Description: Resubmission of 23/03312/ELUD Removal of single storey prefabricated conservatory extension to side and replaced with masonry built single storey side extension, elevational alterations.

LAWFUL DEVELOPMENT CERTIFICATE (EXISTING)

## RESUBMISSION FOR CERTIFICATE OF LAWFUL DEVELOPMENT EXISTING USE

Mr & Mrs Hamilton 2 Melody Road Biggin Hill TN16 3PG	ISSUE DATE: 13/11/2023
PROJECT TITLE: SIDE EXTENSION	
DRAWING TITLE: EXISTING FRONT & SIDE ELEVATION	
DRAWING STATUS: PLANNING	REVISION:
PROJECT NO: PLN - 270	DRAWING NO: DRW - EPLN.4 RSB-11-23
1:50 SCALE	PRINTED @ A2

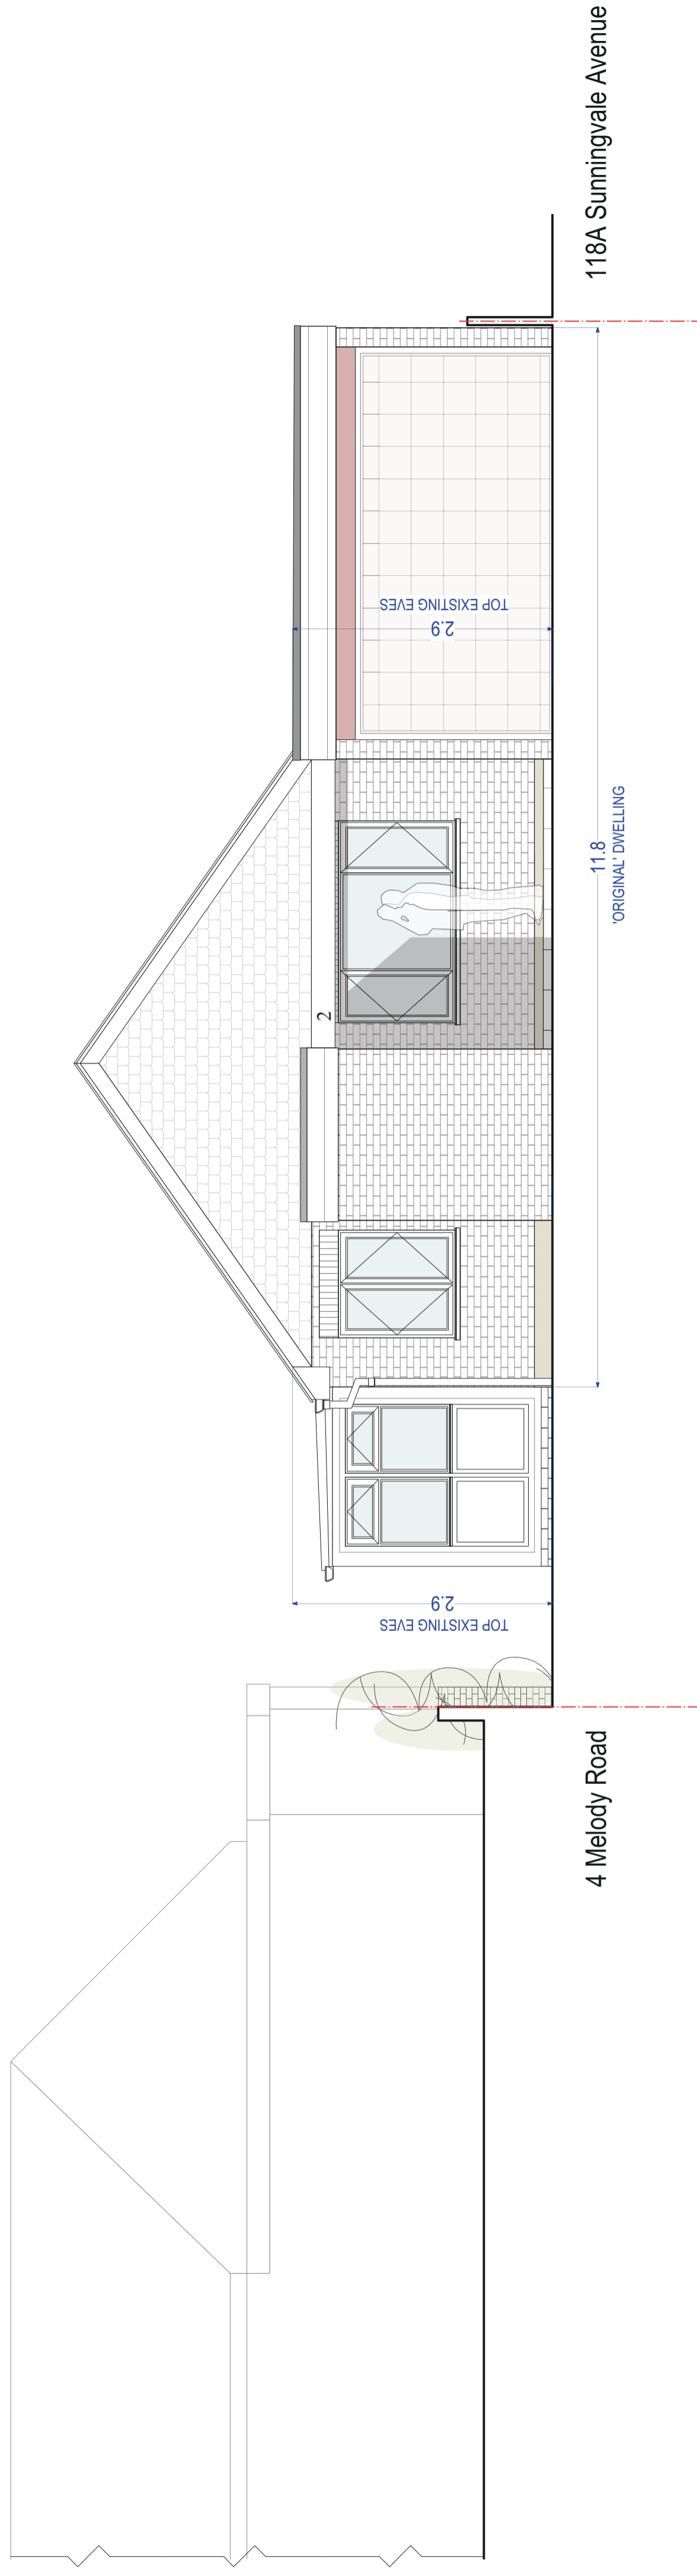
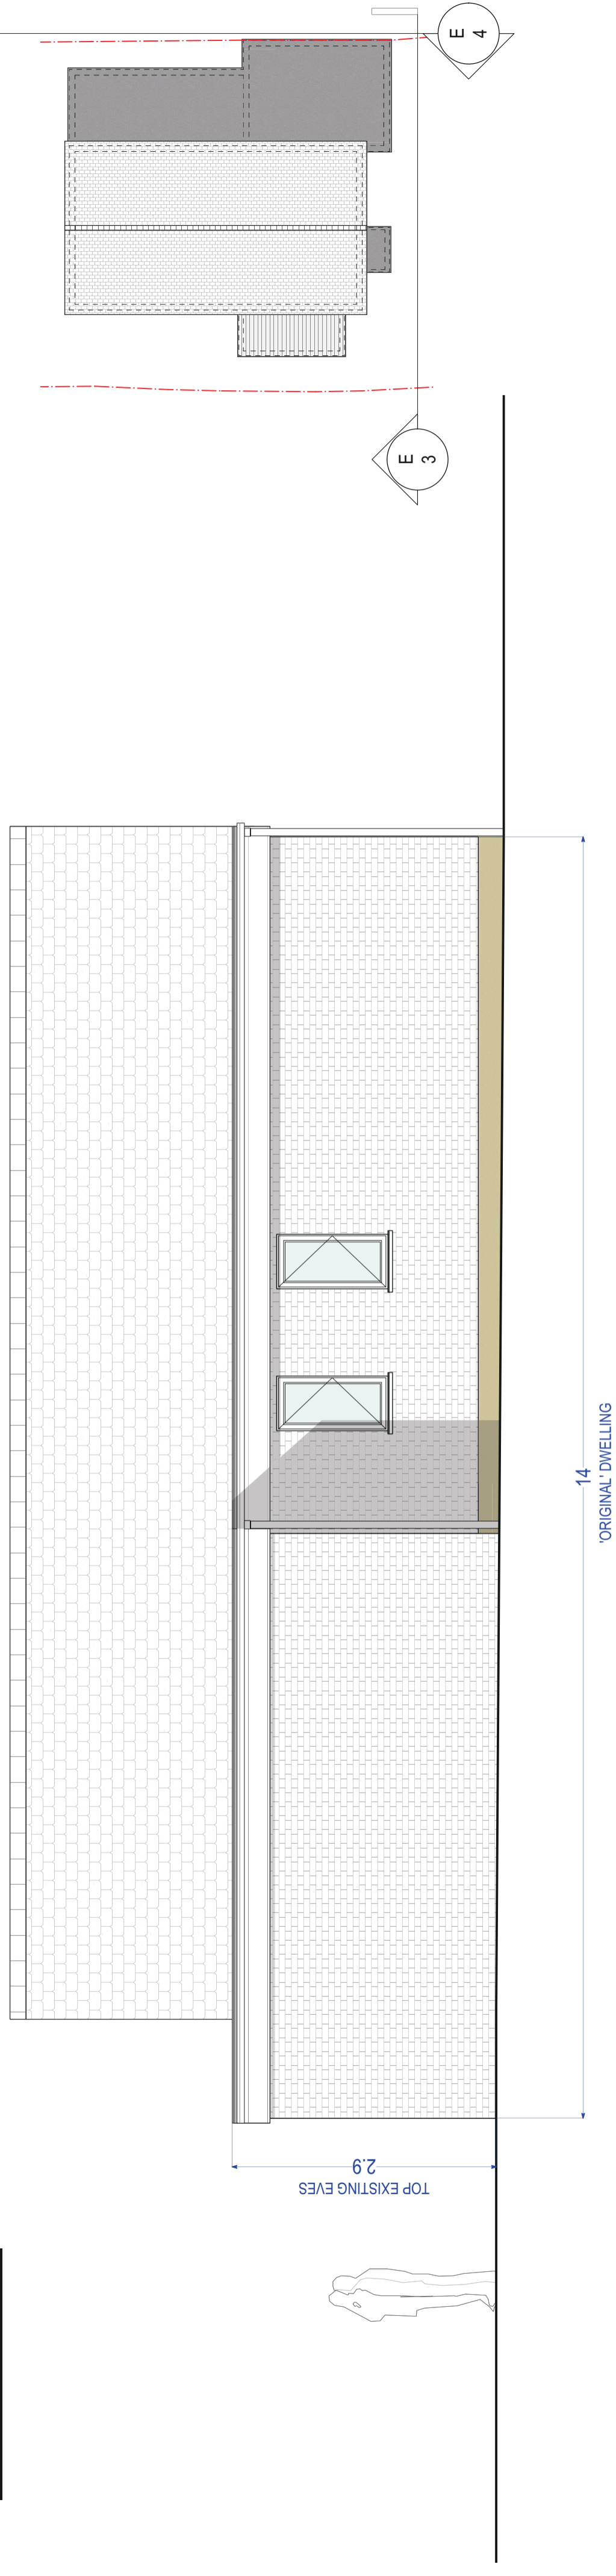
- Under Class A.1(d), a development is not considered permitted development where "the height of the eaves of the part of the dwellinghouse enlarged, improved or altered would exceed the height of the eaves of the existing dwellinghouse".
- The eaves height of the main dwellinghouse is 2.74m and the eaves height of the proposed extension is 2.94m.
- The application form also states that works commenced on 01/08//2023.

The supporting drawings & photographs, provided with this statement and as part of this application, demonstrates that the eaves height of the original dwelling, as seen externally by the soffit & fascia finish 2.9m, not the top of the fascia, and is the point at which the top of the original flat roof, or eaves, above the garage meets the pitched roof of the dwelling.
